**TR010034 – A57 Link Roads**  
**DEADLINE 4 SUBMISSION**  
**But now made in time for DEADLINE 5**  
v2 with material added Friday, 25 February 2022  
Daniel Wimberley, Date Friday, 25 February 2022  
*Unique Reference: 20029775*

**INFORMATION FAILINGS OF HIGHWAYS ENGLAND WITH  
REGARD TO THE A57 LINK ROADS**

HIGHWAYS ENGLAND’S TRAFFIC MODEL THEIR TRANSPORT ASSESSMENT  
REPORT, OTHER INFORMATION FAILINGS AND SUGGESTED ACTIONS FOR THE  
EXA TO TAKE

**6.4 Environmental Statement
Figure 5.1 Air Quality Constraints Map**

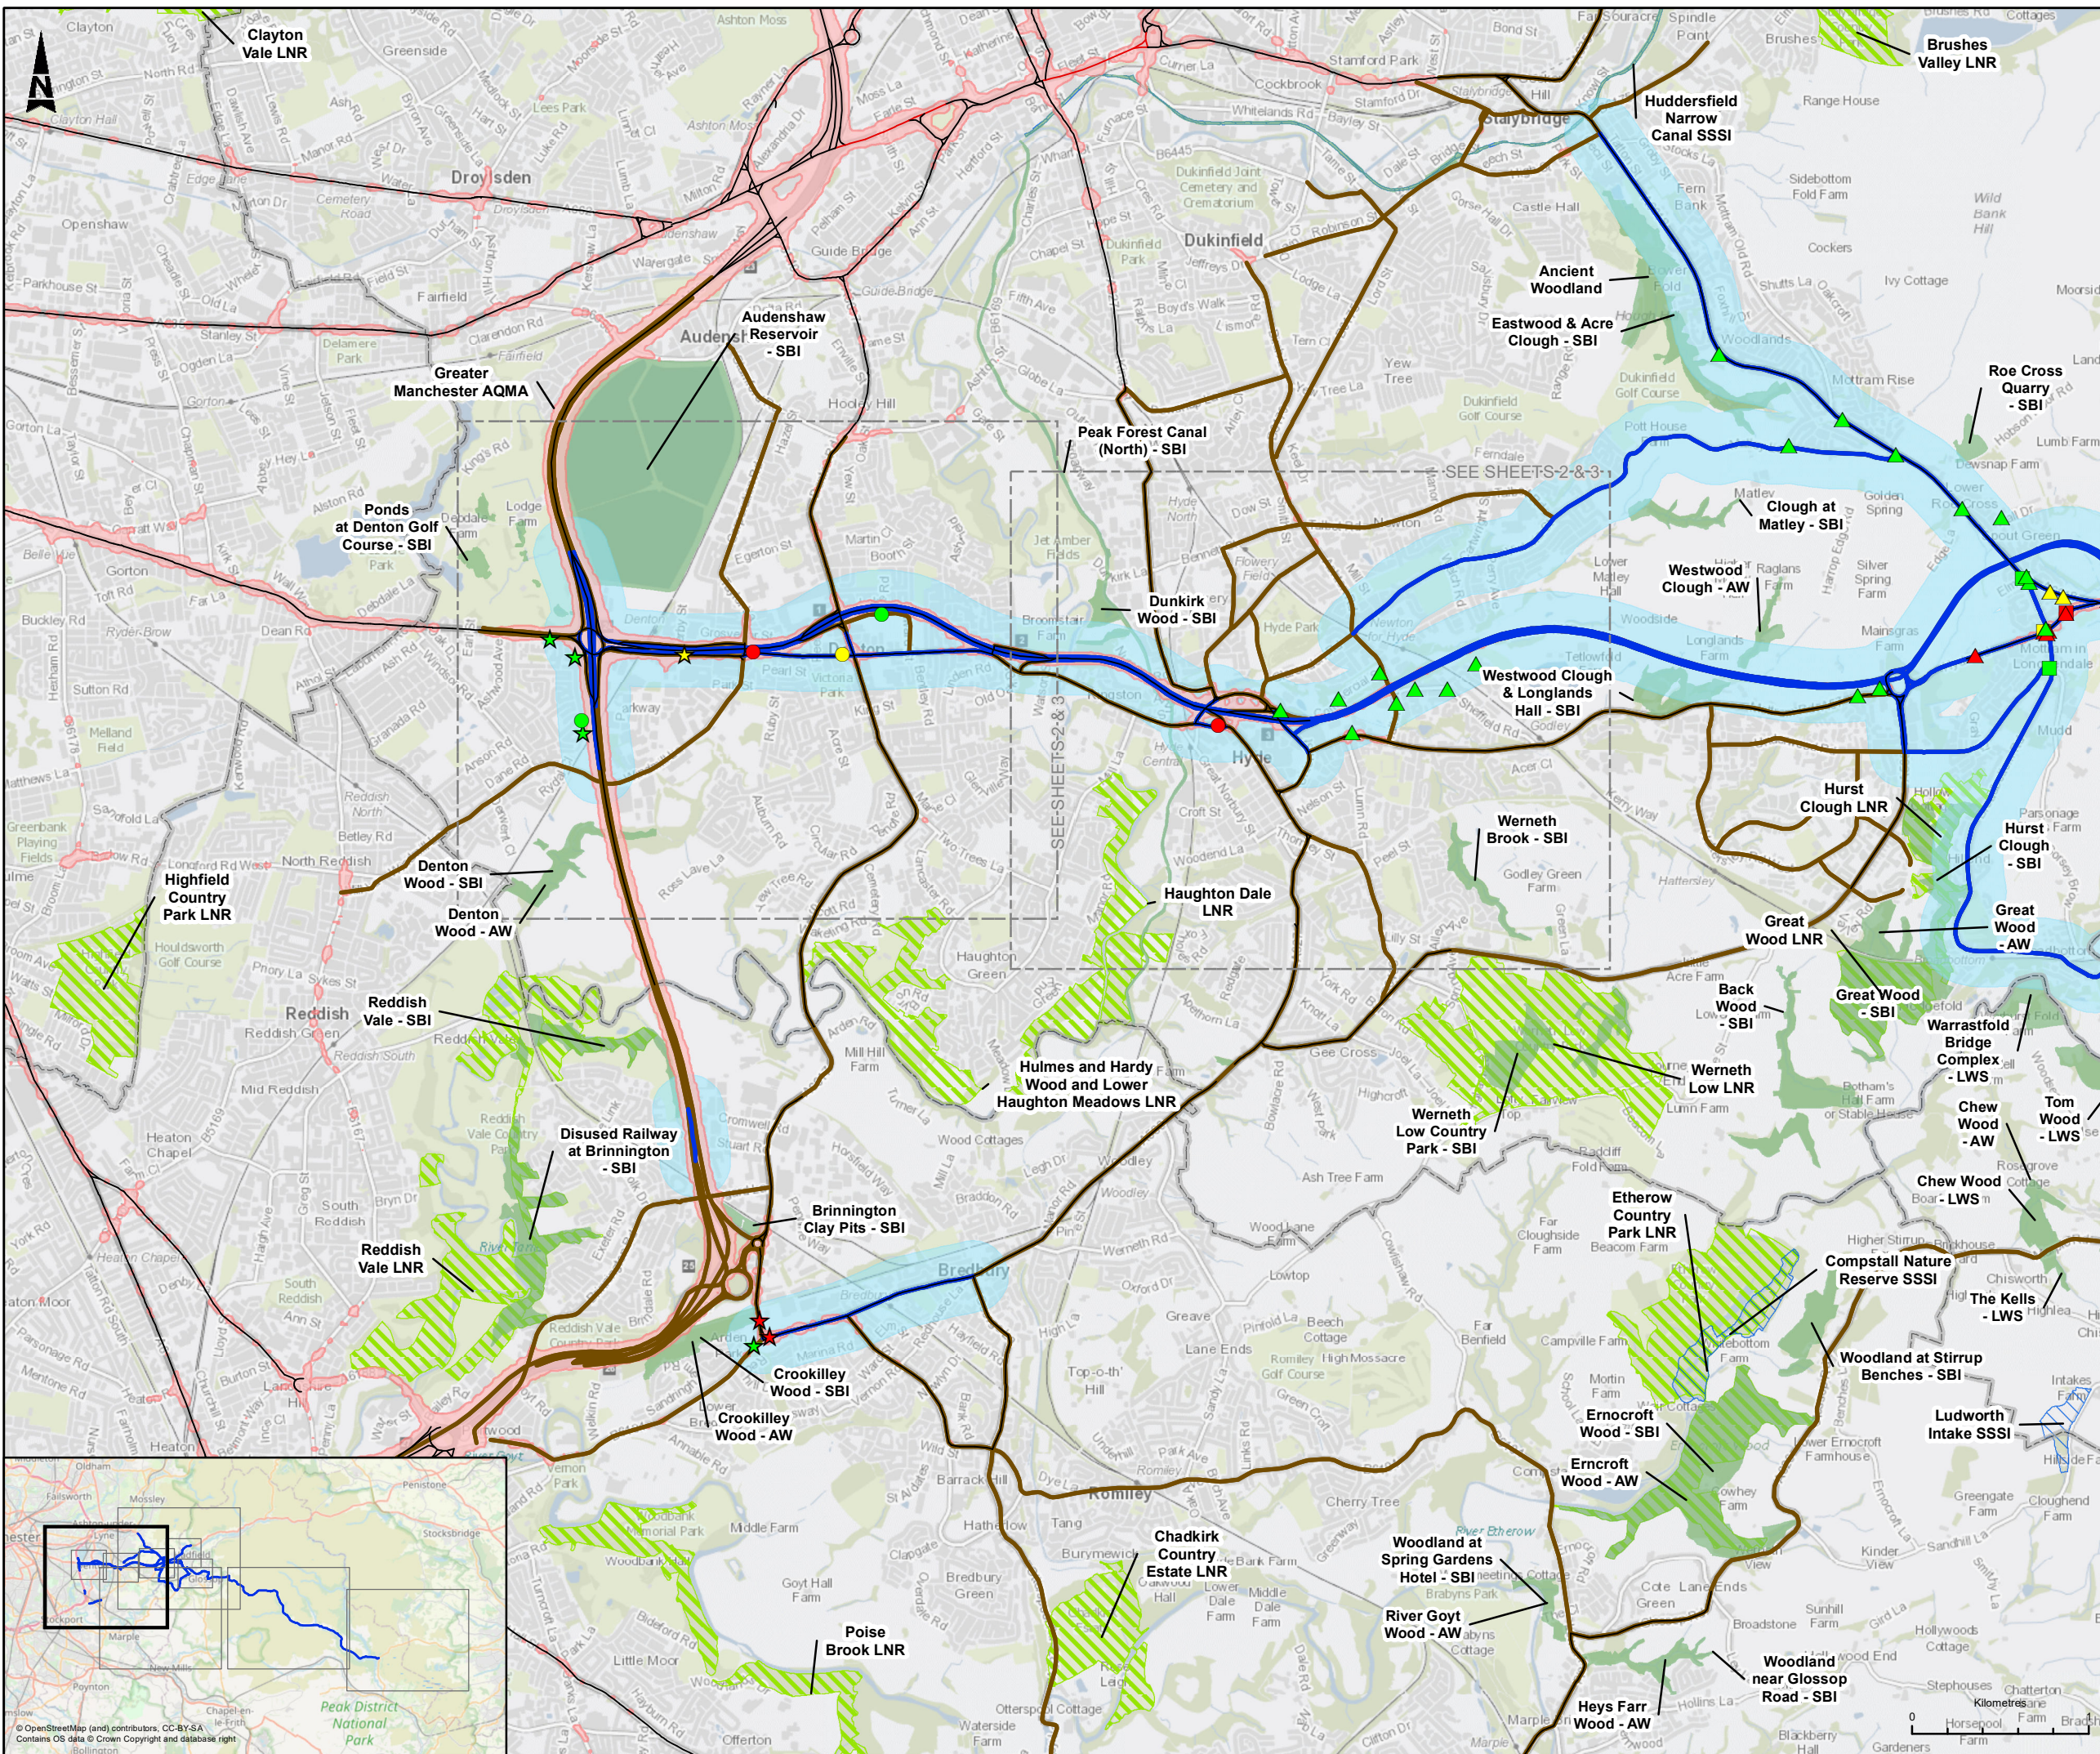
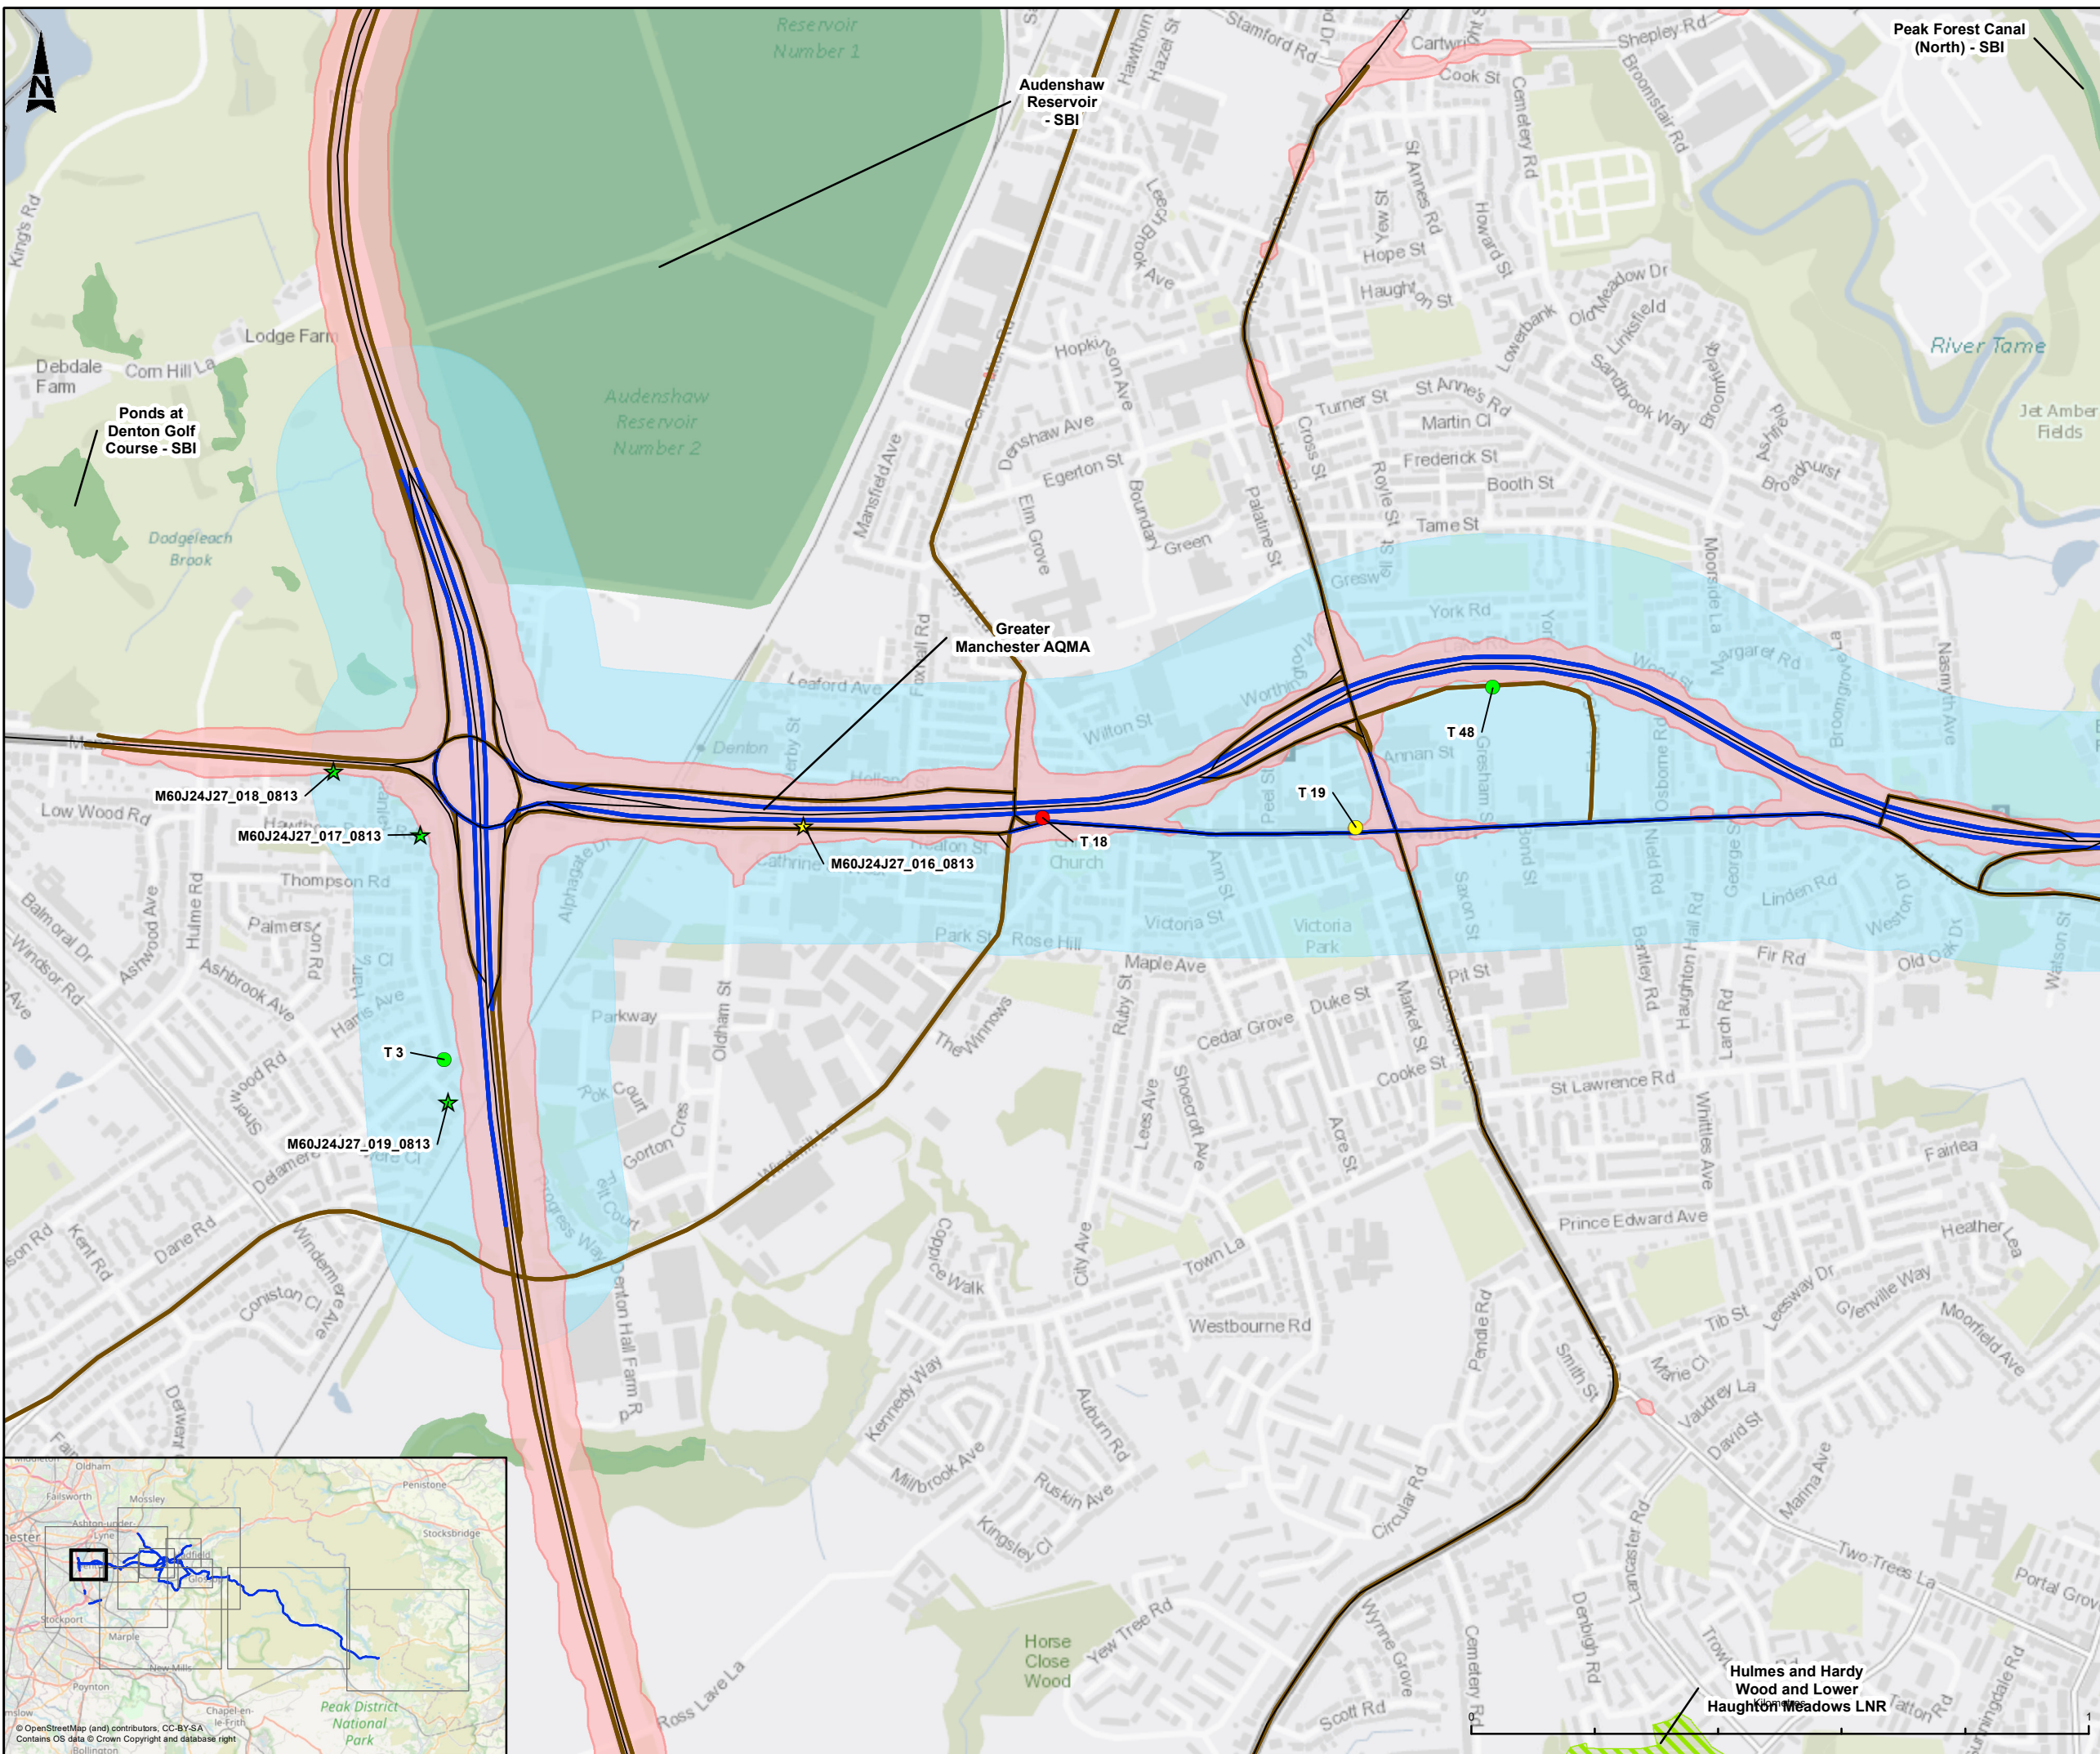
10. The question of **AQMA’s being excluded from assessment** because the increase in flows from DM to DS is “not big enough” made more transparent by slide 9, where they are shown on the map. The relevance of all these key messages is then quite clear. *(slide 9)*

3. As a thought experiment, let us adopt a hypothesis that HE have a great desire NOT to assess AQ issues in the AQMA's of Tintwistle, Dinting Vale and Glossop.

4. For example, in Tintwistle, what matters is the difference between the DS figure and the DM figure **as a number and not as a percentage**. And the other thing that matters is that **that number is less than 1000**.

5. If you apply, say a 10% increase, to a flow of 10,000 you get a numerical increase of 1000. The modelled figure is actually 9699. Et voila – the increase is now 969. *Sorry folks, but the AQMA will not be assessed.*

6. And if you apply, say a 10% increase, to a flow of 11676 (the DfT 2019 estimate for Tintwistle), which is presumably connected to the (accurate) ATC count back on the M67, then you get a numerical increase of 1167. *Oh dear, the AQMA will have to be assessed.*
7. I am NOT saying that DS is derived from DM in this way. But DM and DS figures are connected because the model which gives rise to them stays the same. What matters is the size of the gap, and whether it shrinks when the 2025 DM flow is dramatically altered downwards.
8. The other thing which matters is whether or not we can have faith in the model itself!
